SP-23-00010 NH2G – Delvo KVFR Comment Explanation

Joe Delvo, Fire Prevention Captain and Fire Investigator, provided comments on behalf of the Kittitas Valley Fire and Rescue agency. This document is to provide further explanation of that agency's concerns.

SHEET 1 OF 3

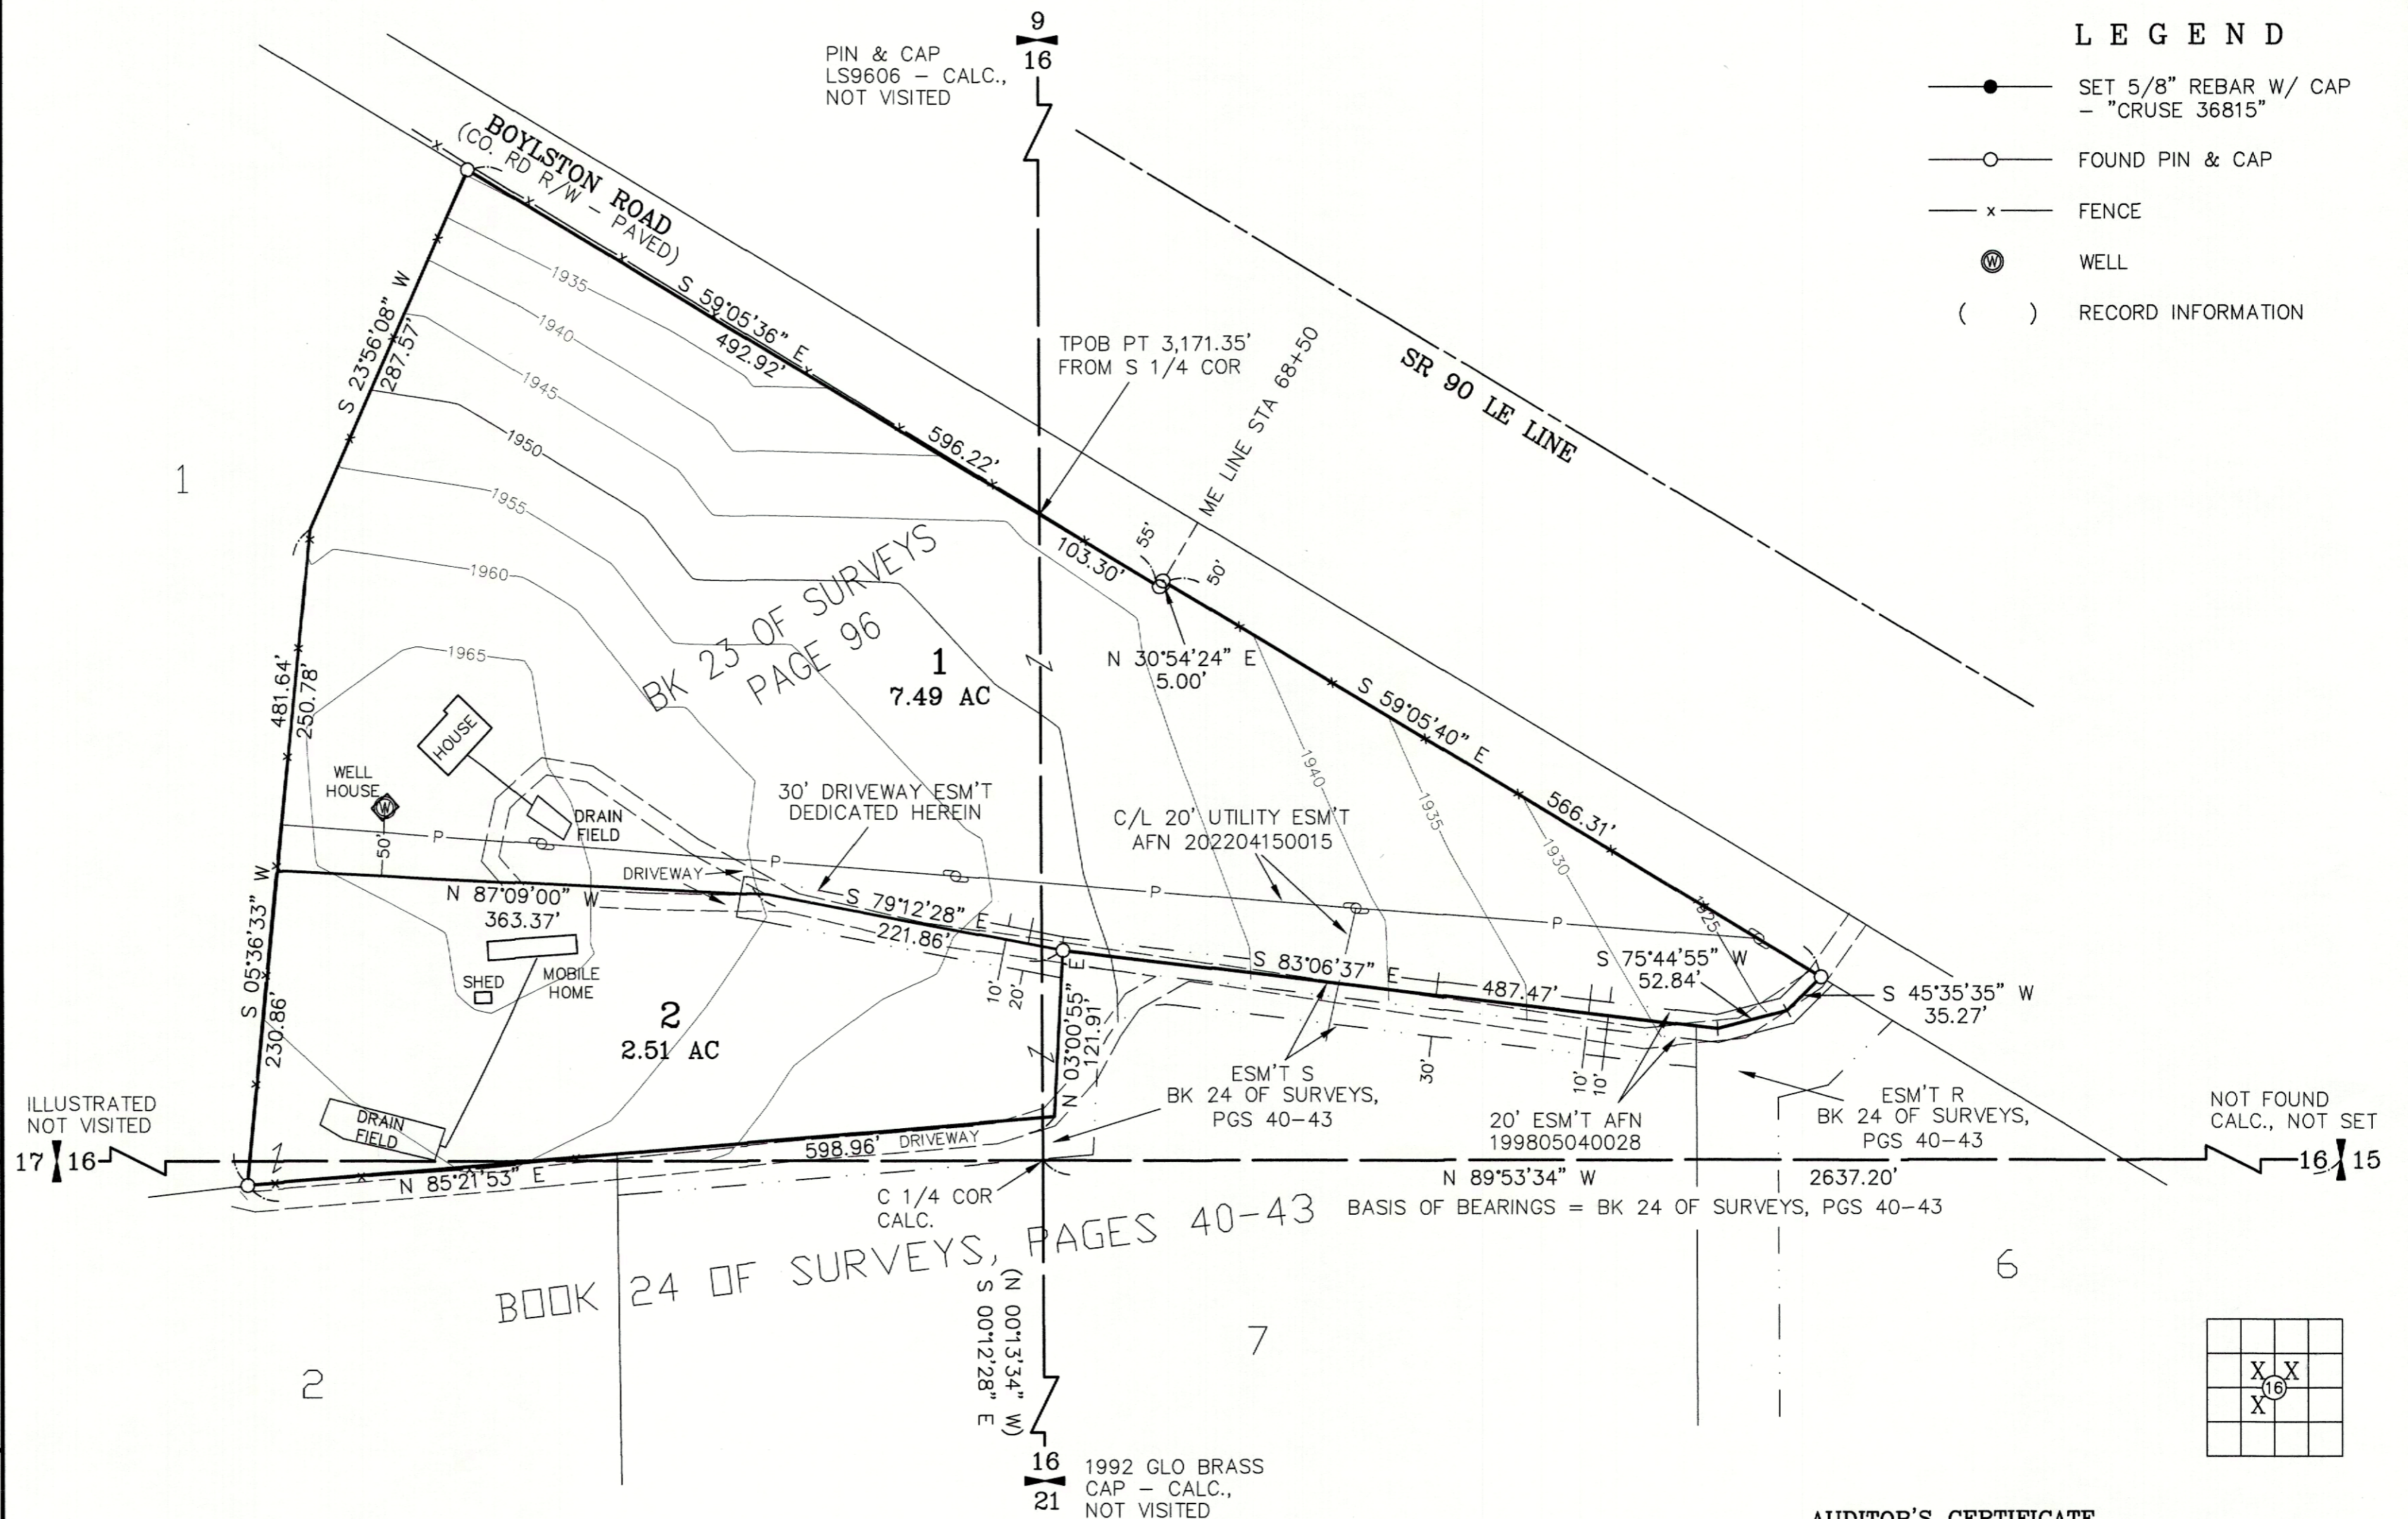
According to Jamey Ayling, Planning Manager of Kittitas County Community Development Services, the applicant will need to build a turnaround & have it be an easement for potential use by Fire and Rescue. The applicant will need an approved fire apparatus turnaround that meets Appendix D of the fire code (2018 IFC).
